WEST SUSSEX COUNTY COUNCIL CONSULTATION

TO:	Arun District Council FAO: James Cross
FROM:	WSCC - Highways Authority
DATE:	18 December 2019
LOCATION:	Swallowfield, Eastergate Lane, Eastergate, PO20 3SJ
SUBJECT:	BN/121/19/PL Removal of redundant polytunnel & construction of 4 bedroom detached chalet bungalow with new vehicular entrance & relocation of Nursery parking area.
DATE OF SITE VISIT:	N/A
RECOMMENDATION:	Advice
S106 CONTRIBUTION TOTAL:	N/A

Existing Site Plan (NTS)

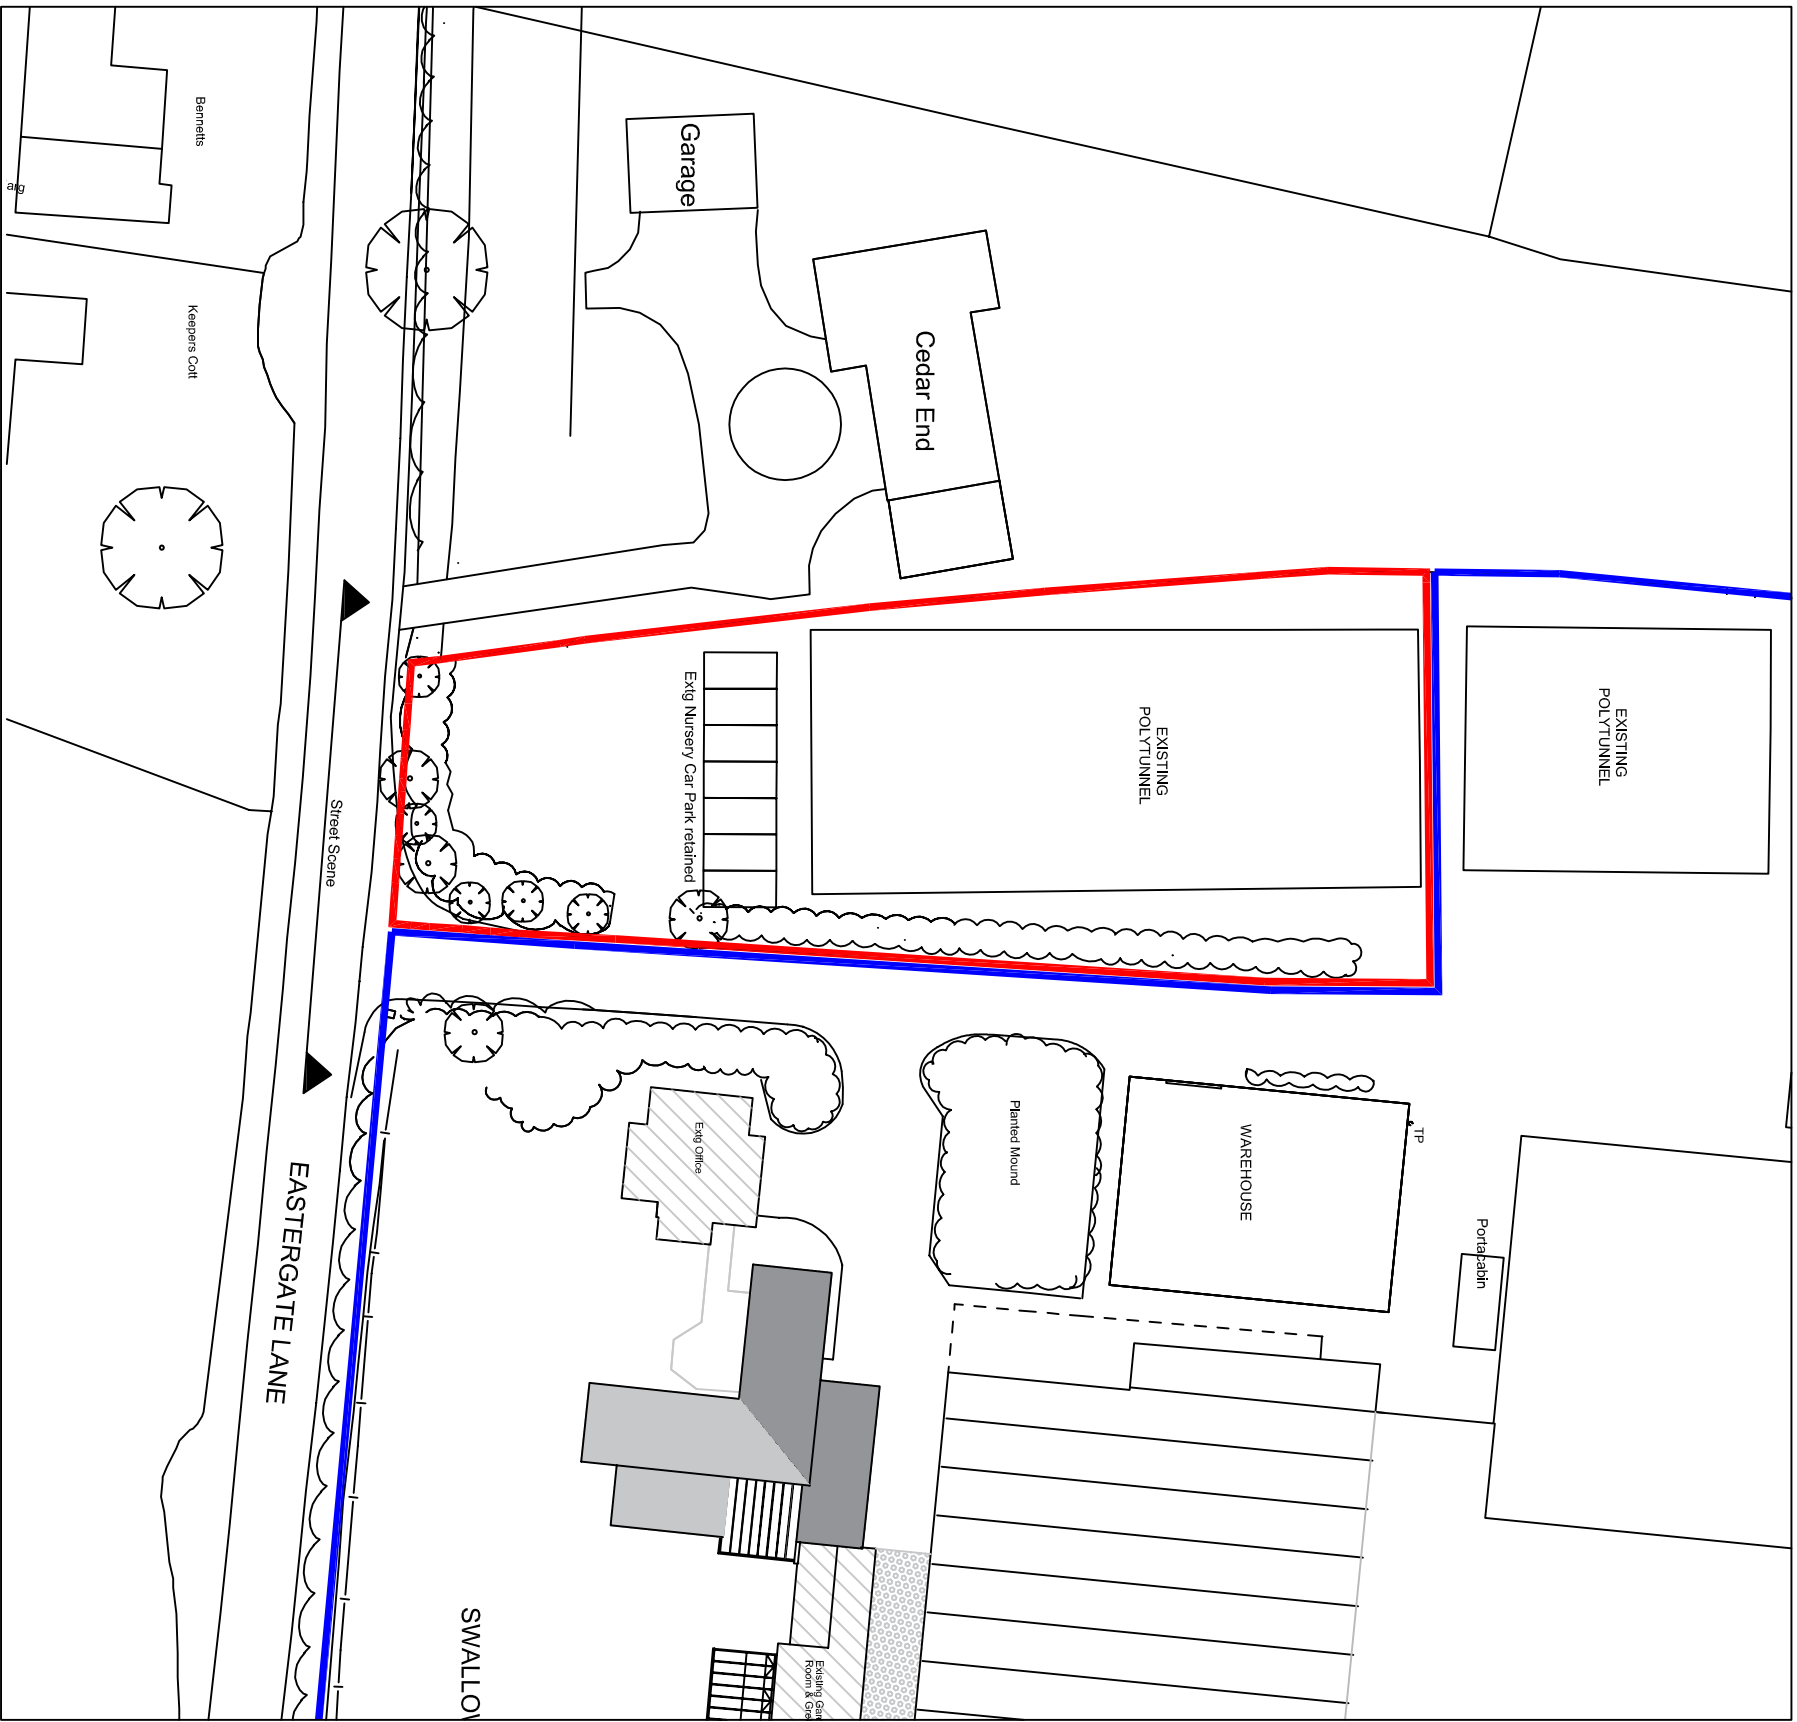
The applicant proposes a new access for the dwelling on Eastergate Road. The access will be subject to a vehicle crossover (VCO) licence obtained through the local area office and constructed to a specification agreed with the local area engineer.

The proposed access will measure approximately 3.5m in width. The proposed gate is to be set back approximately 5.5m from the back edge of the carriageway. This will allow vehicles to remain off the carriageway whilst the gates are in operation.

The LHA acknowledges that visibility at this access does not meet the standards set out in Design Manual for Roads and Bridges (DMRB). However, the LHA appreciates that visibility at the proposed access is comparable, if not better, than the existing access that serves the nursery. An inspection of collision data provided to WSCC by Sussex Police from a period of the last 5 years reveals no recorded injury accidents within the vicinity of the site. Therefore, there is no evidence to suggest the existing access, which currently accommodates a number of vehicular movements, is operating unsafely or that the proposal would exacerbate an existing safety concern.

A new driveway and carport will provide vehicular parking for the new dwelling. The WSCC Car Parking Demand Calculator has indicated that a dwelling of this size in this location would require three car parking spaces. The driveway is of sufficient size to allow for three car parking spaces

The applicant has not demonstrated cycle parking in the plans. Under WSCC parking standards, residential dwellings with 3 or more bedrooms should provide secure and covered cycle parking for at least 2 cycles. The inclusion of cycle parking helps promote the use of sustainable alternative modes of transport to the private car.

In terms of the nursery car parking, 11 car parking spaces will be situated north of the proposed dwelling. The spaces meet the minimum MfS specifications of 2.4m x 4.8m. There is sufficient room for vehicles to manoeuvre in and out of the spaces and exit the site in a forward gear.

No part of the development shall be first occupied until covered and secure cycle parking spaces have been provided in accordance with plans and details submitted to and approved by the Local Planning Authority.
